Engineers Comments Regarding Surface Water Drainage

Application Reference:	AL/6/25/DOC	Reviewer Reference:	ADC/EXT4
Planning Officer:	Hannah Kersley	Date of Review:	21/11/2025
Site Name:	8 Autumn Gate Hook Lane Aldingbourne PO20 3TE		
Application Description:	Approval of details reserved by condition imposed under reference AL/75/24/HH relating to condition number 4 - surface water drainage scheme.		
Assessment Number:	2 of 2

PROPOSED DRAINAGE STRATEGY (scale 1:100)

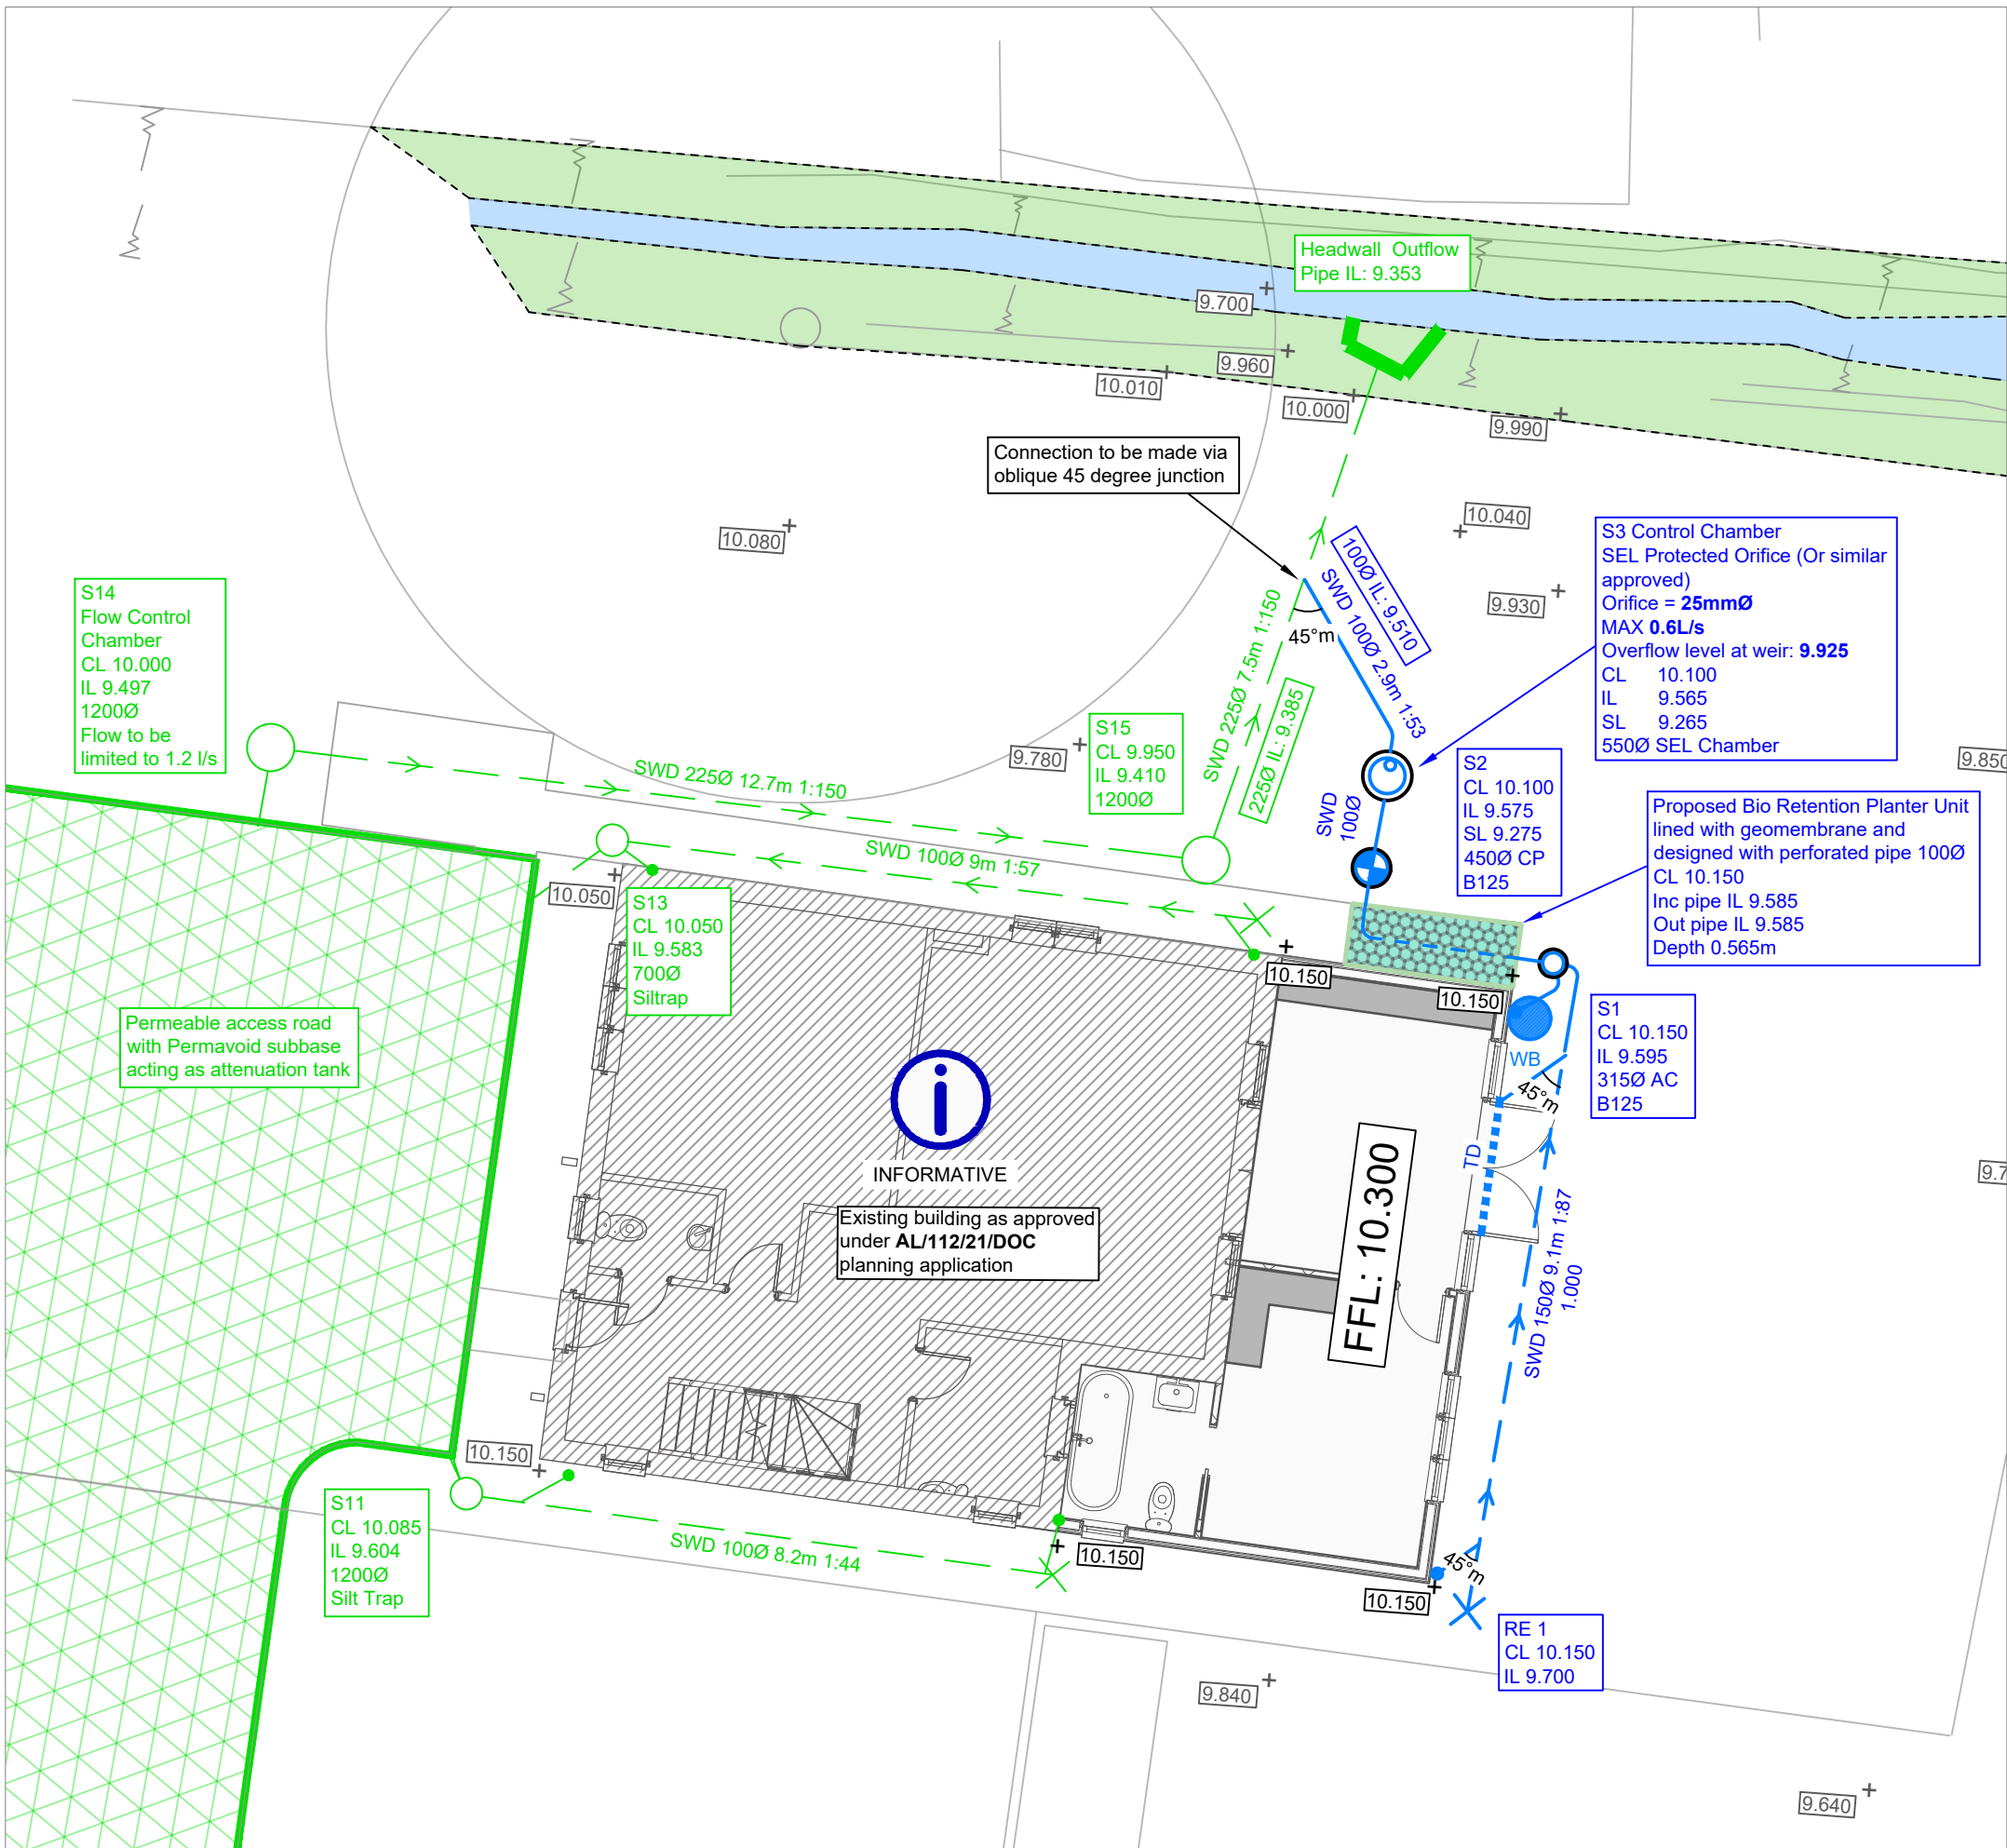
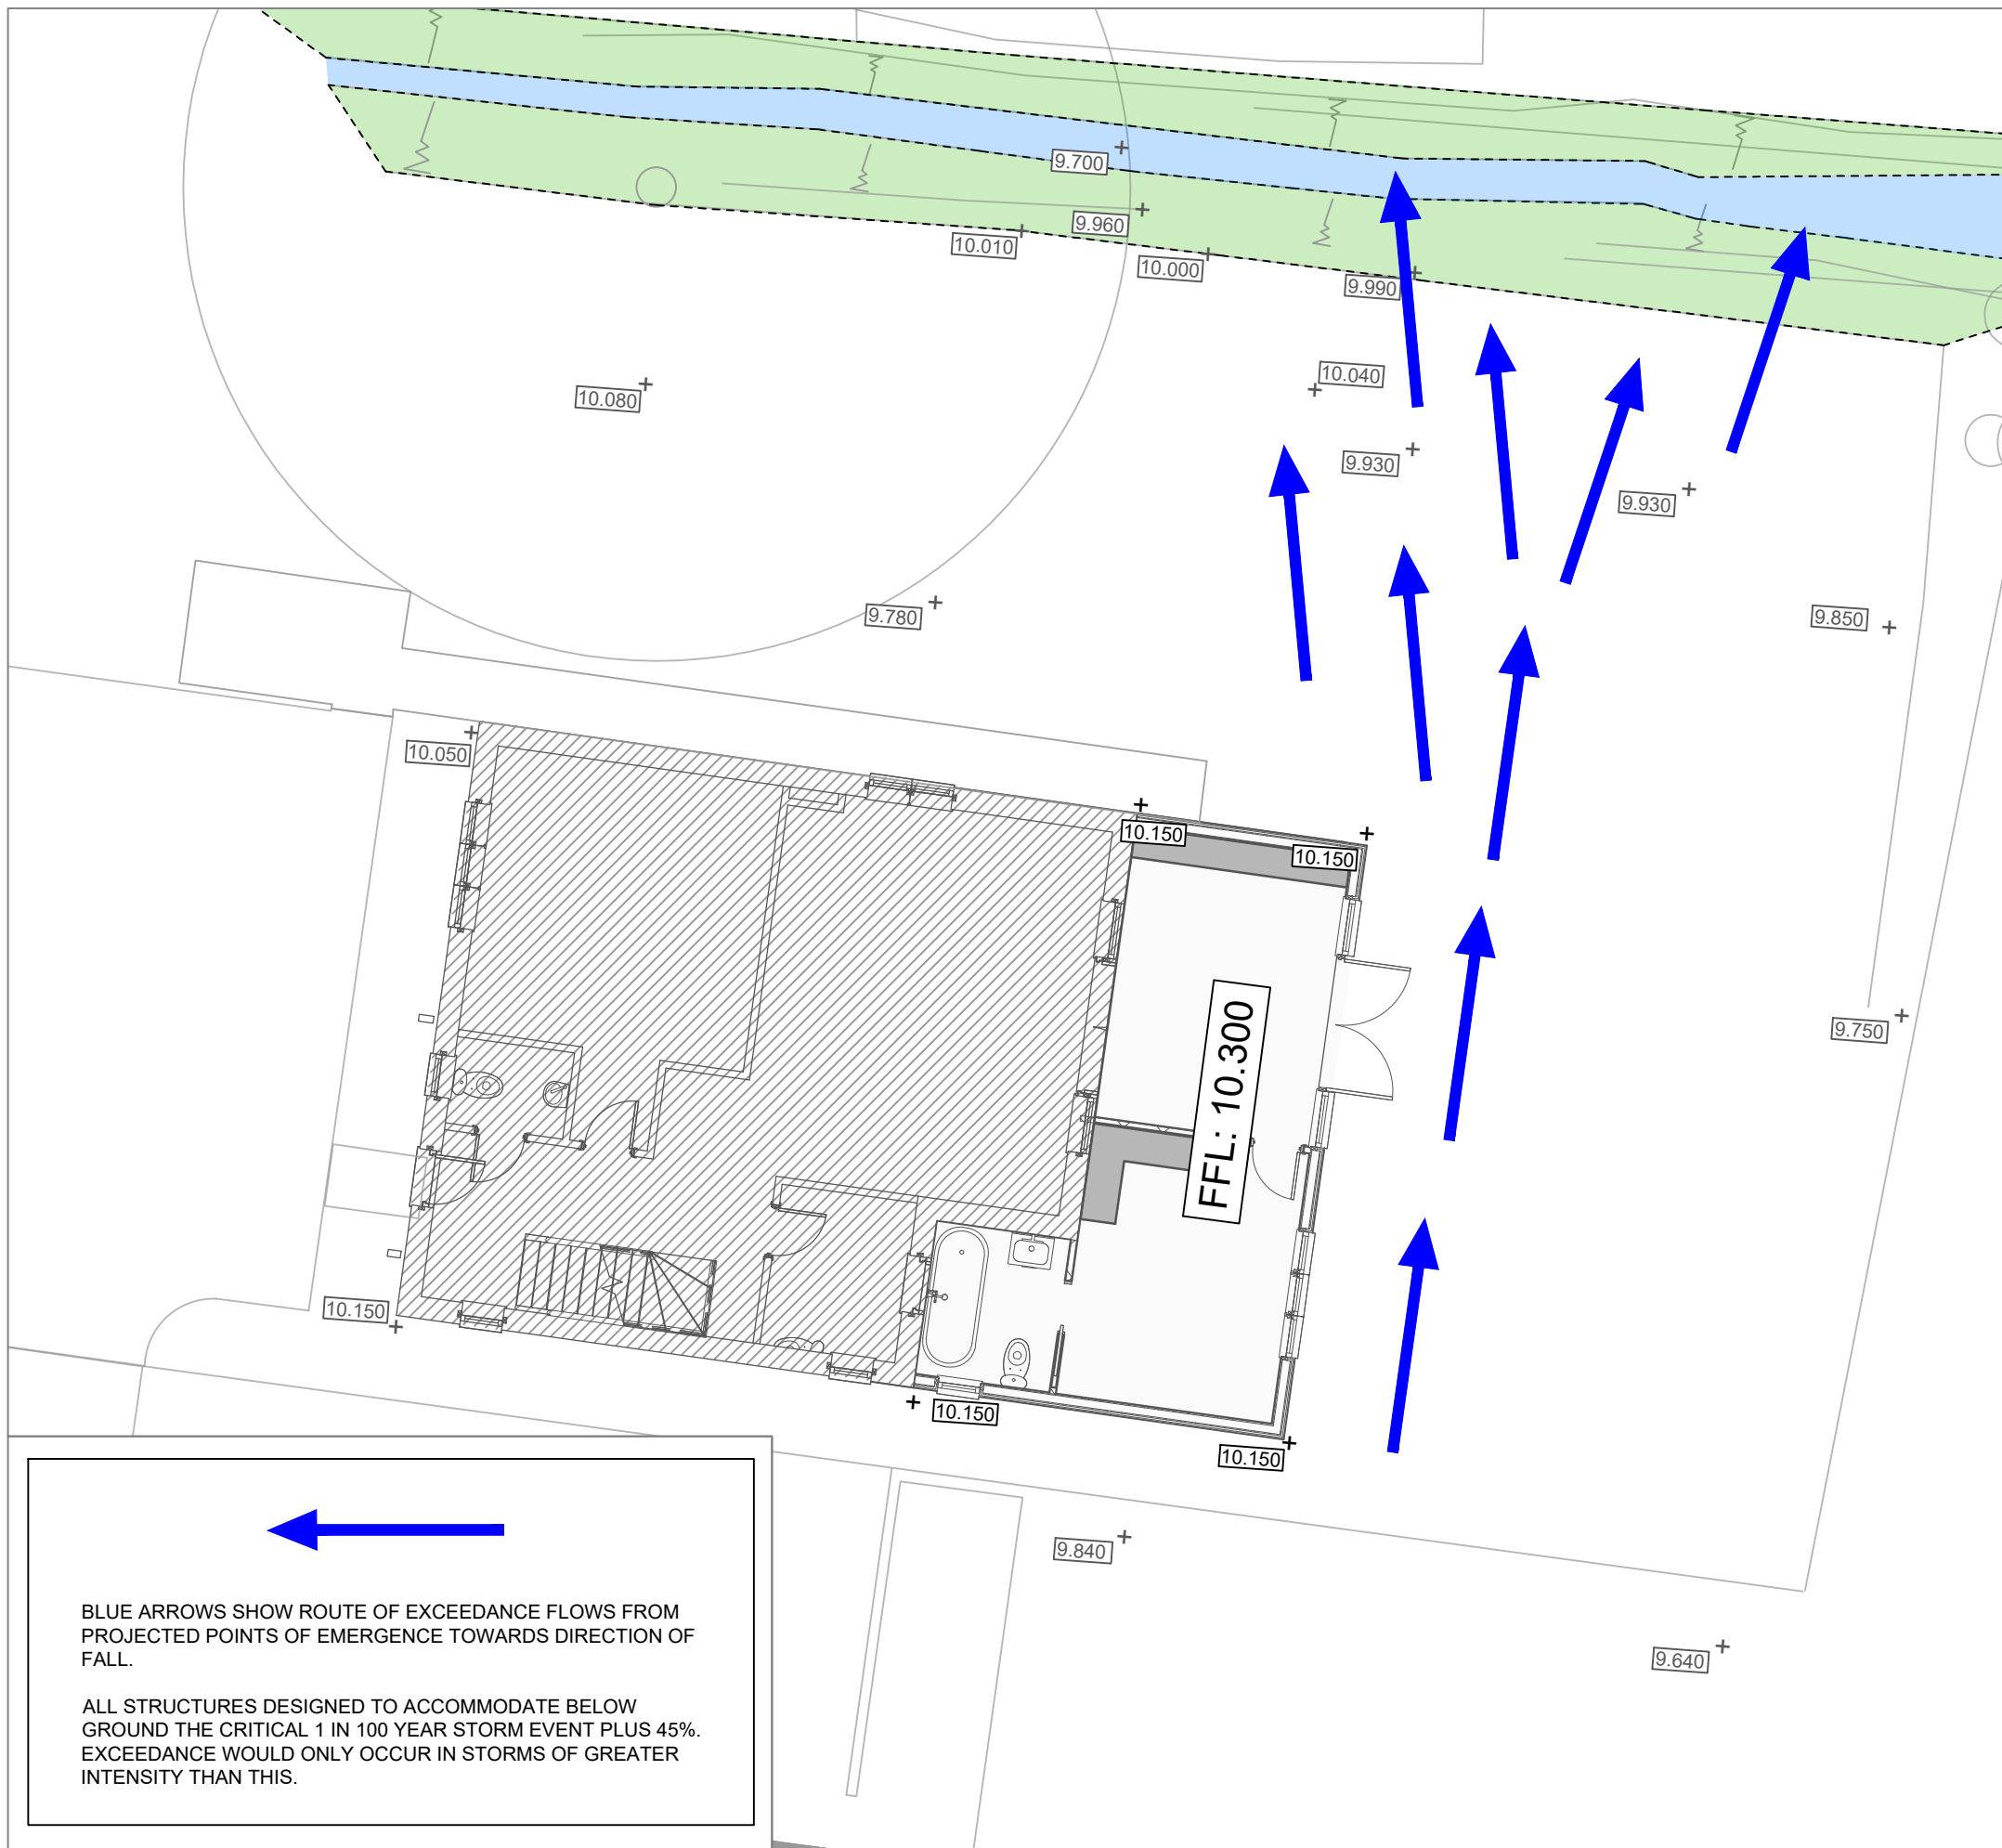
Comment History	ADC Drainage Comments	Designer Response	ADC Drainage Comments	Designer Response
Date:		01/10/2025	08/10/2025		
Condition Number: 4					
Comment Number					
1.	ADC Drainage Response (AL-6-25- DOC) 15/07/2025 Where the existing pipe is being connected to, specify an oblique 45 degree junction or new manhole. Designer response (AL-6-25- DOC) 25/07/2025 Updated. The oblique 45 degree ensured. ADC Drainage Response (AL-6-25- DOC) 26/08/2025 Please advise where the drawing has been updated to reflect this Designer response (AL-6-25- DOC) 04/09/2025	Item now closed

Specify sump depth on construction detail Designer response (AL-6-25-DOC) 04/09/2025 Noted. It has been updated-please see Proposed Typical Construction Details Rev. P2				
4.	ADC Drainage Response (AL-6-25- DOC) 15/07/2025 Where the threshold drain is being connected to pipeline Re1 to S1, specify an oblique 45 degree junction. Similar comment for the RWP on the SE corner Designer response (AL-6-25-DOC) 25/07/2025 Updated. ADC Drainage Response (AL-6-25- DOC) 26/08/2025 Clearly indicate that these connections will be made using oblique 45 degree junctions. Designer response (AL-6-25-DOC) 04/09/2025 Noted. The oblique 45 degree junctions have been described and marked on the drawing, indicating their exact locations. Please refer to the Proposed Drainage Strategy Rev P2.	Noted and closed

Noted. The oblique 45 degree junctions have been described and marked on the drawing , indicating their exact locations. Please refer to the Proposed Drainage Strategy Rev P2.

450mmØ/600mmØ Turtle Enviro Silt Trap Detail
(scale 1:20)

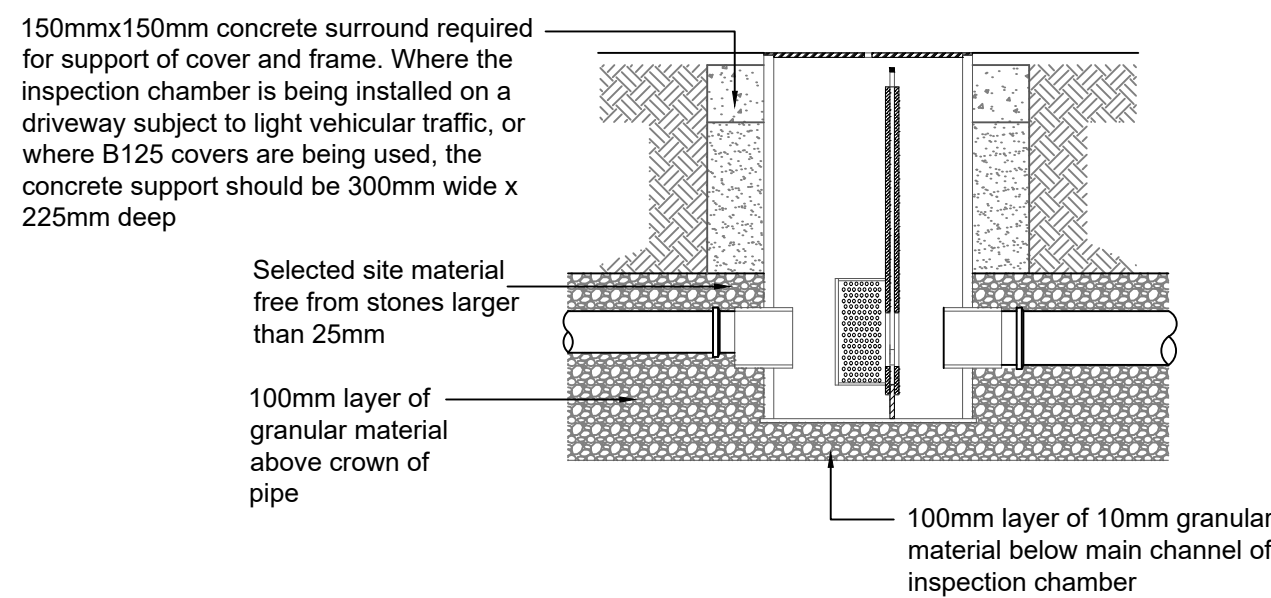
3.	ADC Drainage Response (AL-6-25- DOC) 15/07/2025 Provide a suitable catchpit upstream of the flow control chamber, ensuring all flows have to pass through this chamber. Include full construction details. Designer response (AL-6-25-DOC) 25/07/2025 Updated. ADC Drainage Response (AL-6-25- DOC) 26/08/2025	Noted and closed

Typical BIO Retention Planter Detail
(not to scale)

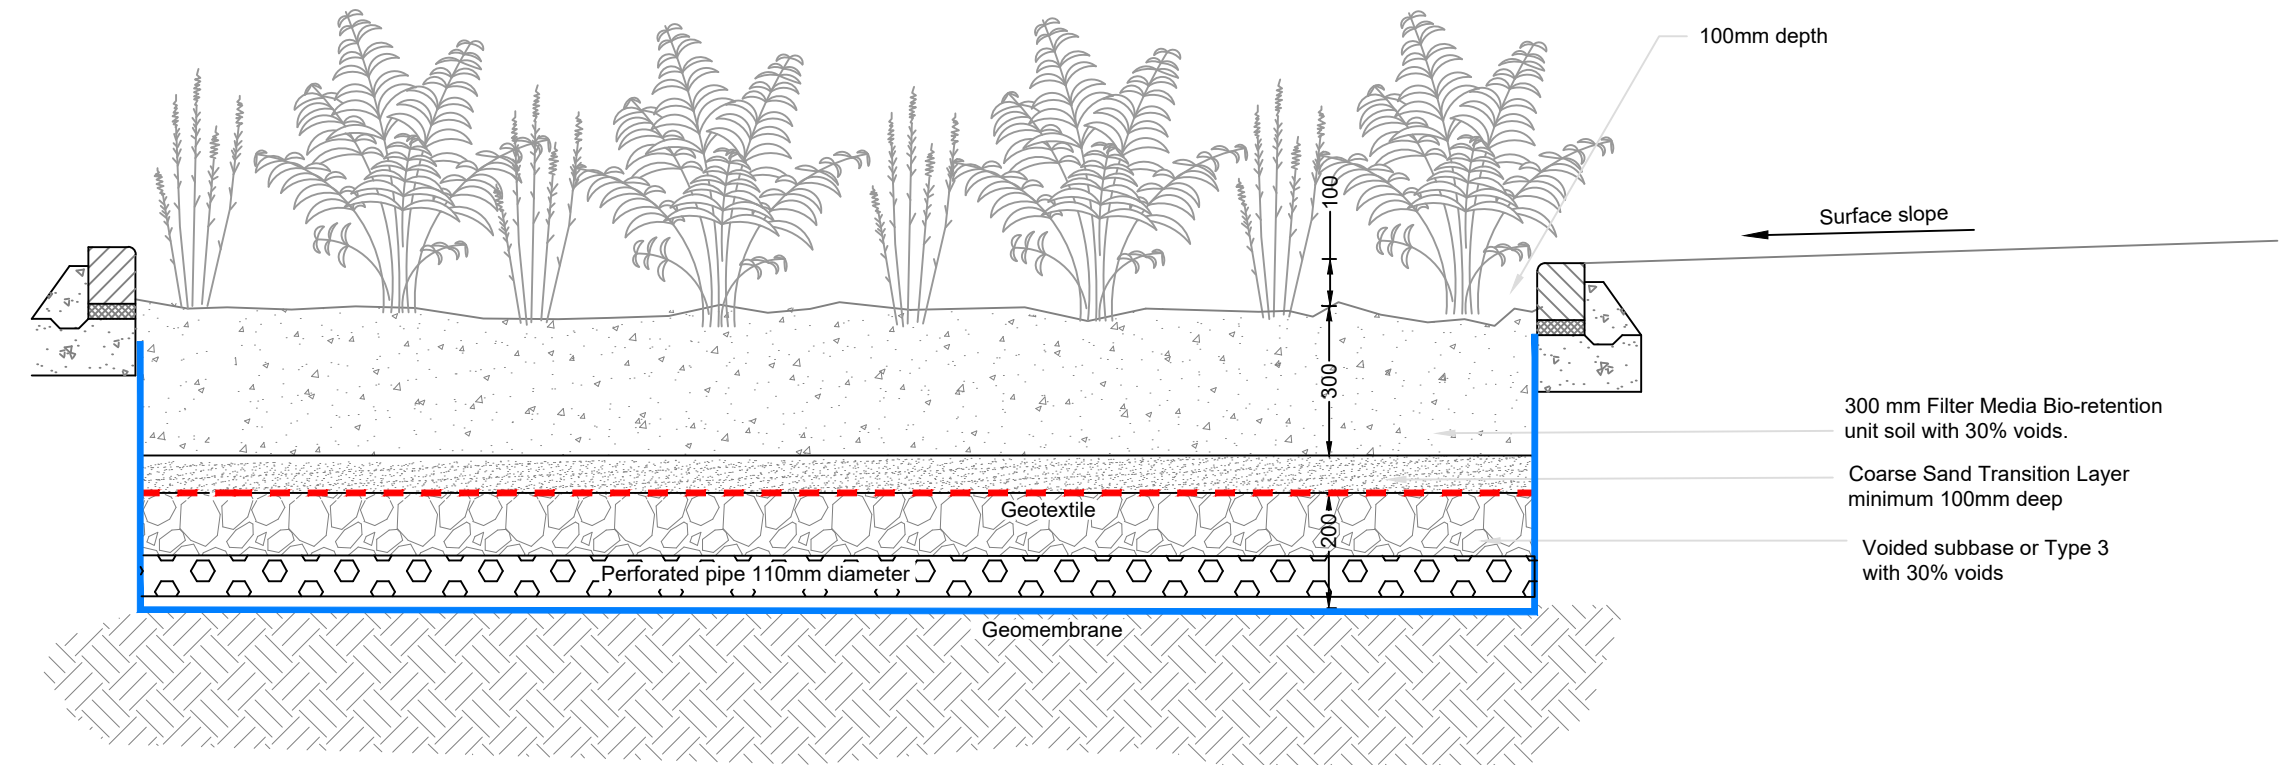
2.	ADC Drainage Response (AL-6-25- DOC) 15/07/2025 Please provide interception drainage to ensure that the first 5mm of rainfall over the proposed impermeable area is not discharged from the site. Ie. rainwater harvesting, etc. Designer response (AL-6-25-DOC) 25/7/2025 A water butt will be provided to capture the first 5mm of rainfall, in line with the interception drainage requirement. ADC Drainage Response (AL-6-25- DOC) 26/08/2025 Water butt proposed to serve part of roof only. However, Standard 2 of the National harvesting, etc. Standards advises that water butts do not achieve the interception requirements, unless they can be demonstrated to comply. Please review. Full construction details will be	Whilst the use of the bio-retention planter is welcomed, please review the detail. Currently the perforated pipe and inlet to this system is at the base of the planter. As such the initial surface water run-off will miss the benefits of the planter and not provide the level of treatment/interception required. Please consider either raising the inlet level or dropping the finished level of the planter to achieve the full benefit of the raingarden. As a minimum we the inlet should be no deeper than 250mm below the finished level of the planter to achieve the required interception and we would expect a maximum void ratio of 20%	Noted. The inlet level to the proposed bioretention planter has been raised to 9.760 m AOD, ensuring it remains no deeper than 0.25 m below the finished level of the planter, which is now set at 10.000 m AOD. The outlet pipe level is 9.560 m AOD, and the base level of the bioretention planter is 9.550 m AOD. Please refer to the updated Proposed Typical Construction Details, Revision P3, which now includes the revised bioretention planter detail. Following the council's comments, the maximum void ratio for the bioretention

required to support any proposal. Designer response (AL-6-25-DOC) 04/09/2025 Noted. The water butt will now be used solely for rainwater reuse and not relied upon for interception. To ensure compliance with Standard 2, we are proposing a lined bioretention planter unit which will capture, convey and store the first 5mm of rainfall, allowing runoff to be naturally absorbed or lost to the atmosphere. The construction detail has been provided-please see Proposed Typical Construction Details Rev. P2		planter has been reduced from 30% to 20% to reflect a more conservative and realistic attenuation capacity based on the planting medium specification.
